Deadline 2 Submission – Comments on Written Representations, Local Impact Reports, Applicant Responses, and New Information

Submitted by: Joanna Styles (Interested Party – Kent) Date: 9 December 2025

Sea Link – EN020026

Document Ref: FIGURE 1	Scale: 1:7,500	Format: A3	Sheets: 1	Rev: 0
------------------------	----------------	------------	-----------	--------

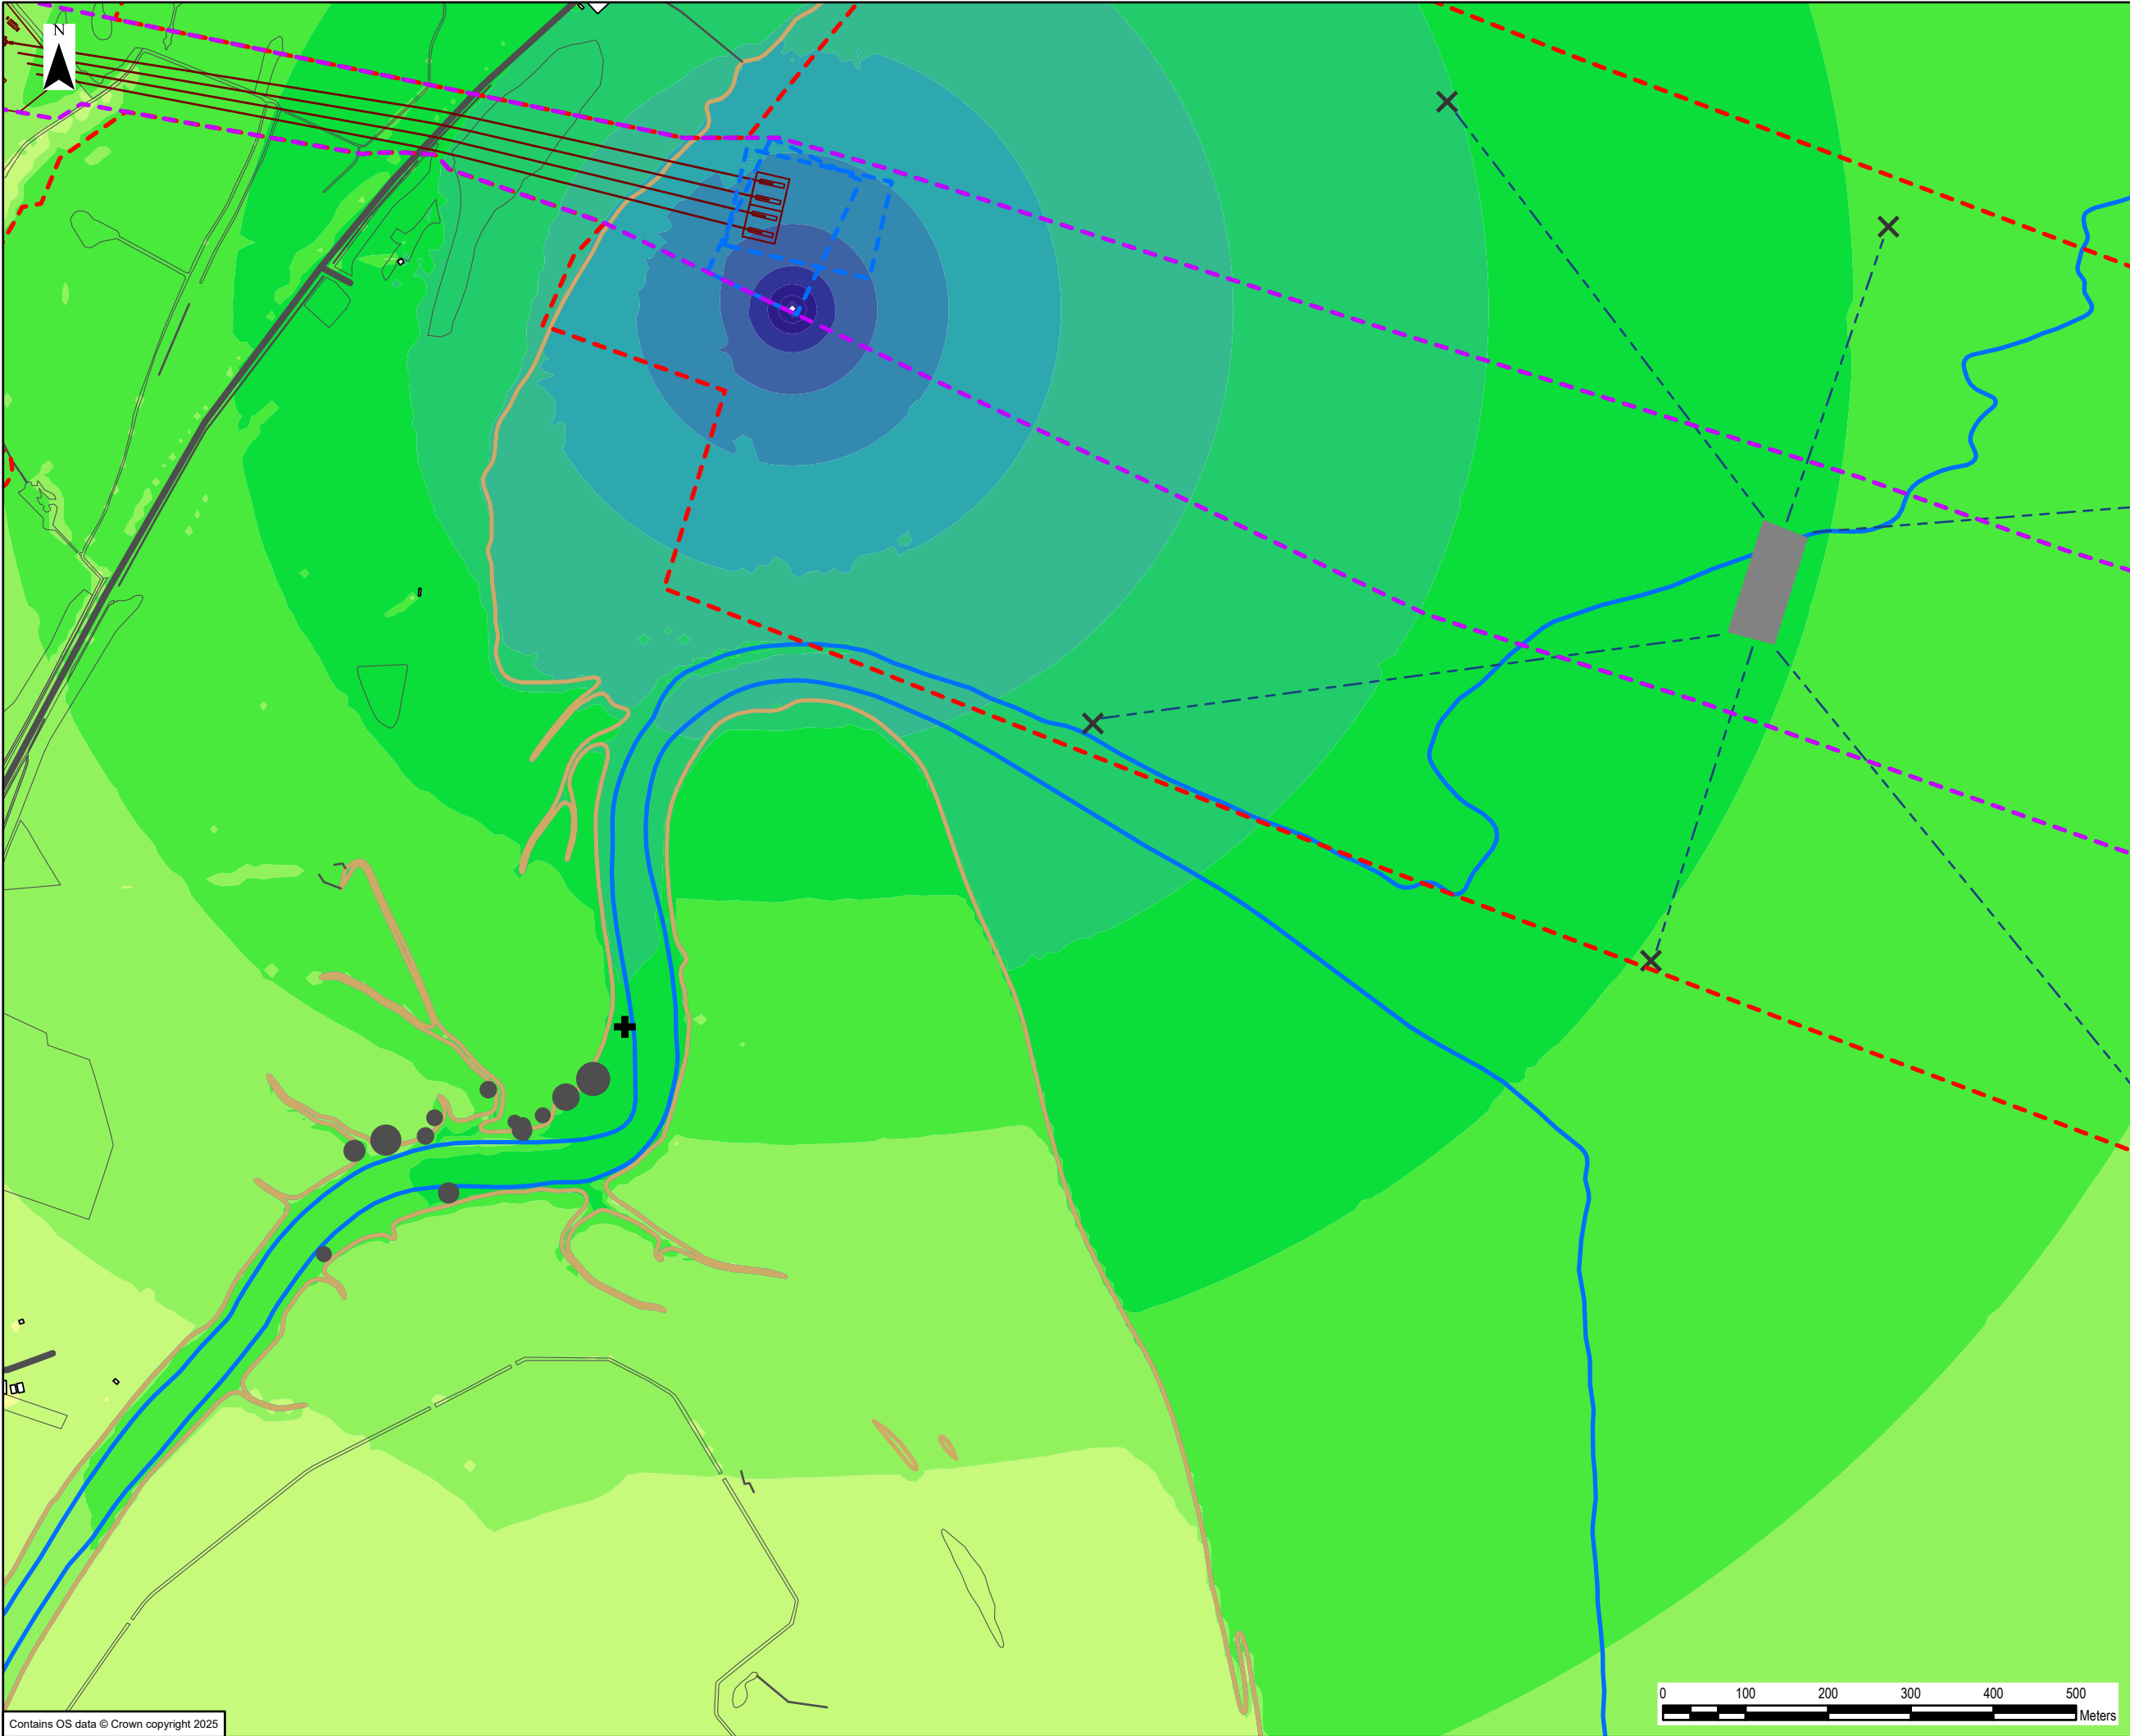
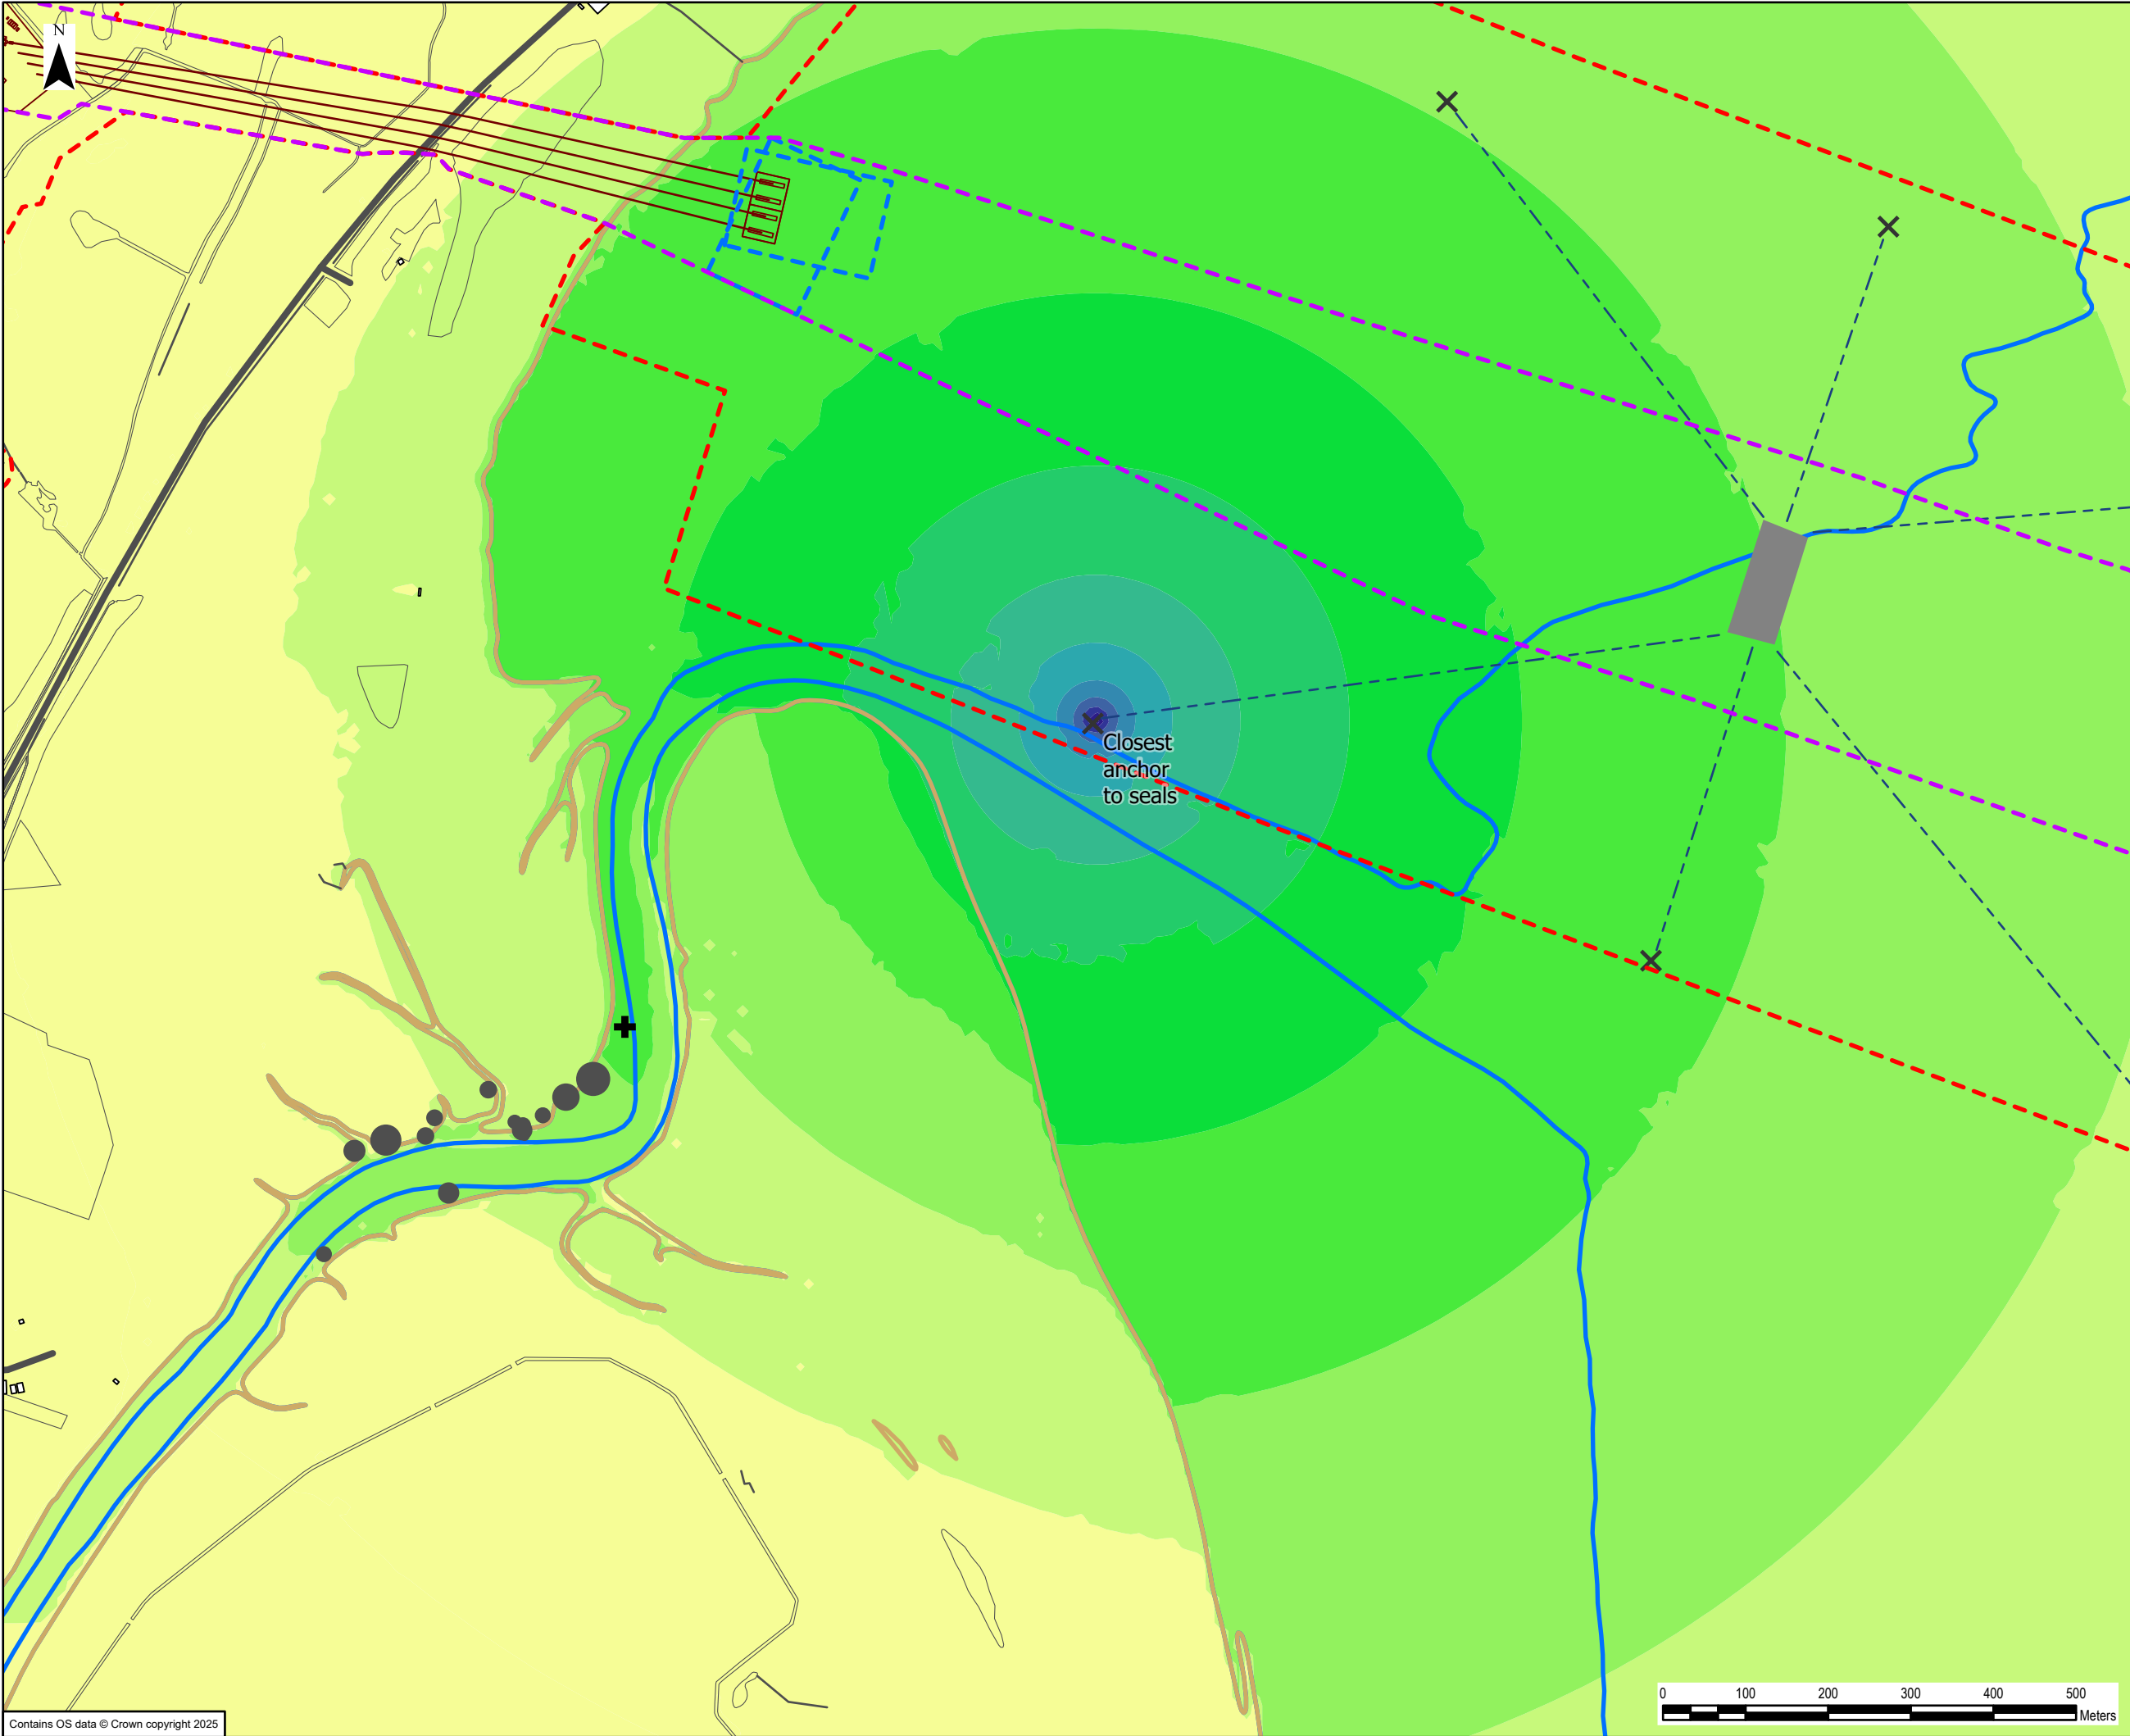
1. The Applicant calculates only TTS/PTS thresholds from airborne noise, not behavioural disturbance.
Behavioural disturbance — *including abandonment of haul-outs* — occurs at far lower levels, and is the primary route by which seals are affected.
2. The model uses M-weighting, which is correct, but the underlying source data remain unchanged from the earlier A-weighted modelling — meaning source uncertainty is not addressed.
3. Reflective surfaces (water, intertidal flats) are treated as “hard” surfaces but no sensitivity analysis is given.
Reflection *increases* effective sound exposure — but this is not explored.
4. The Applicant models only continuous 12-hour use of a vibratory rig + excavators, but does not include:
 - emergency hovercraft deployment
 - unplanned plant movement

2.2.2 Behavioural Disturbance is Not Modelled

Yet the Applicant:

- does not model behavioural thresholds,
- does not quantify changes in haul-out behaviour,
- and fails to consider disturbance to dependent pups.
